**Re: Starbucks at Haines / San Mateo, 2104 San Mateo Blvd NE,
Certificate of Occupancy – Transportation Development
Architect's Stamp dated 2-27-08 (J18-D023)
Certification dated 9-03-08**

Re: Starbucks at Haines / San Mateo, 2104 San Mateo Blvd NE, Traffic Circulation Layout
Architect's Stamp dated 2-27-08 (J18-D023)

Re: Starbucks Coffee Co., Lot 4-A, Grading and Drainage Plan

Re: Starbucks Coffee Co., Lot 4-A, Grading and Drainage Plan
Engineer's Stamp dated 12-04-07 (J-18/D023)

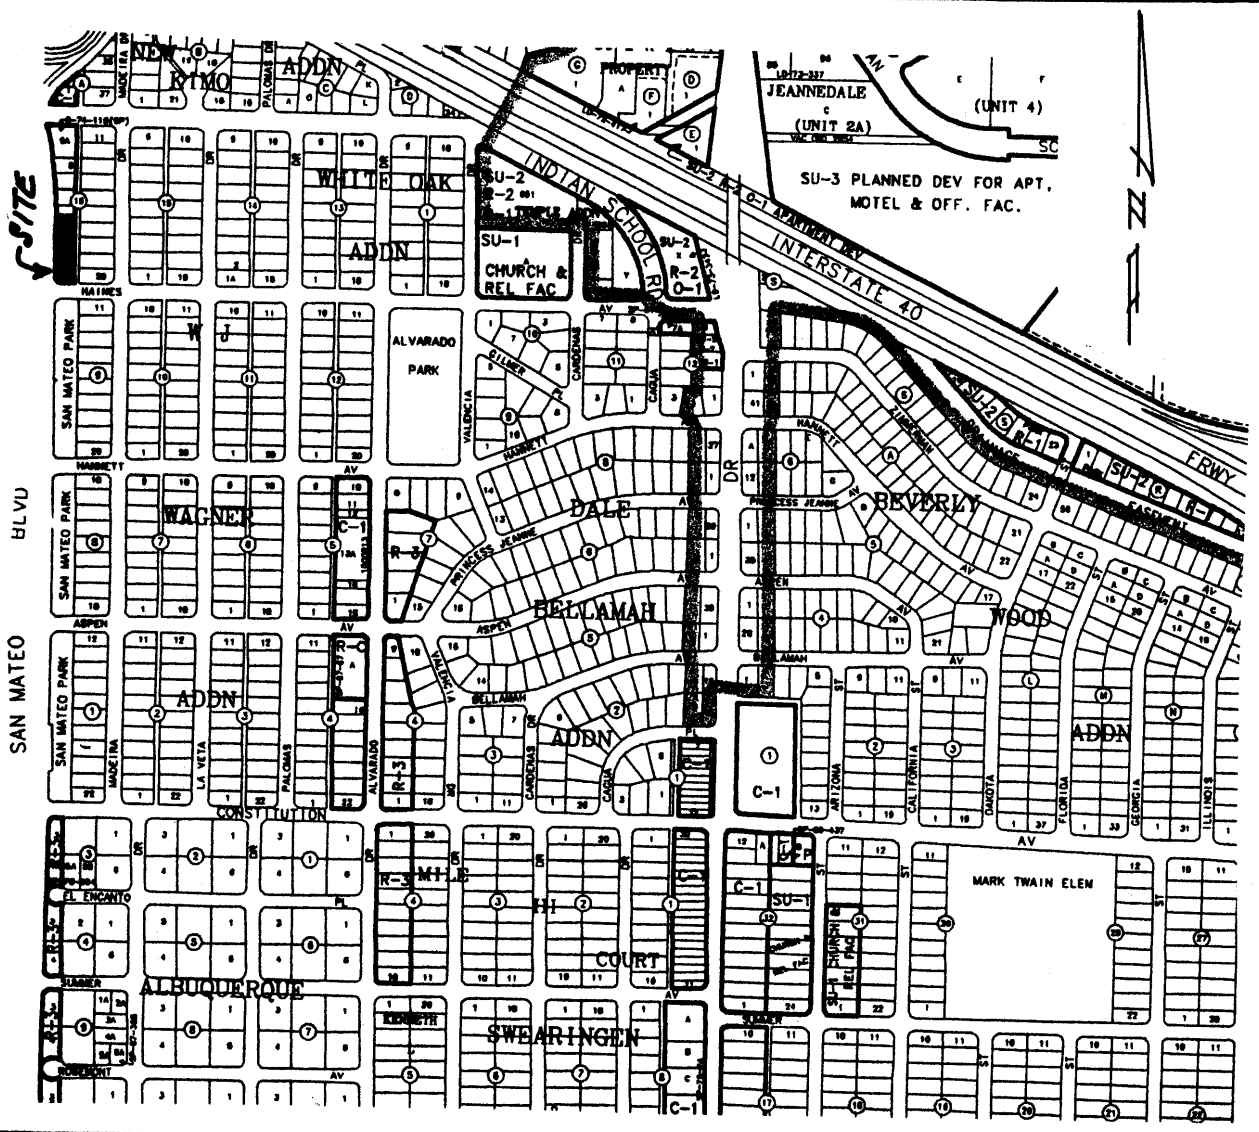
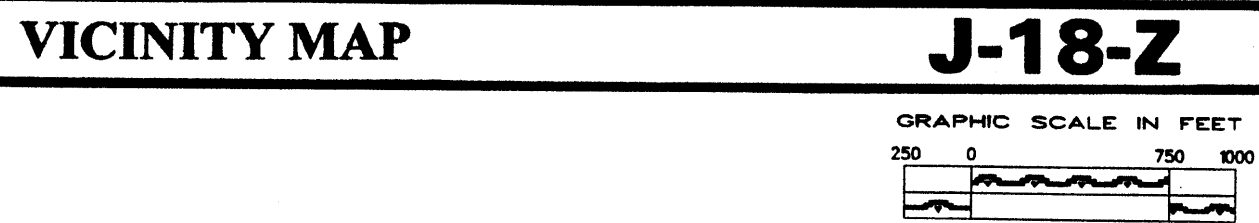
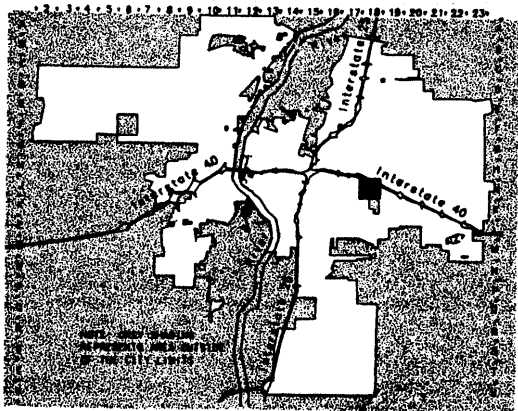
1. Provide the recording information for the 10' wide Private Ingress-Egress & Surface Drainage Easement. Who benefits from this easement?
2. It appears there will be grading on the property to the north; this will require approval from the owner of lot 5-A.
3. Additional elevations will be needed for the motorcycle parking area. This looks like an area where ponding could occur.
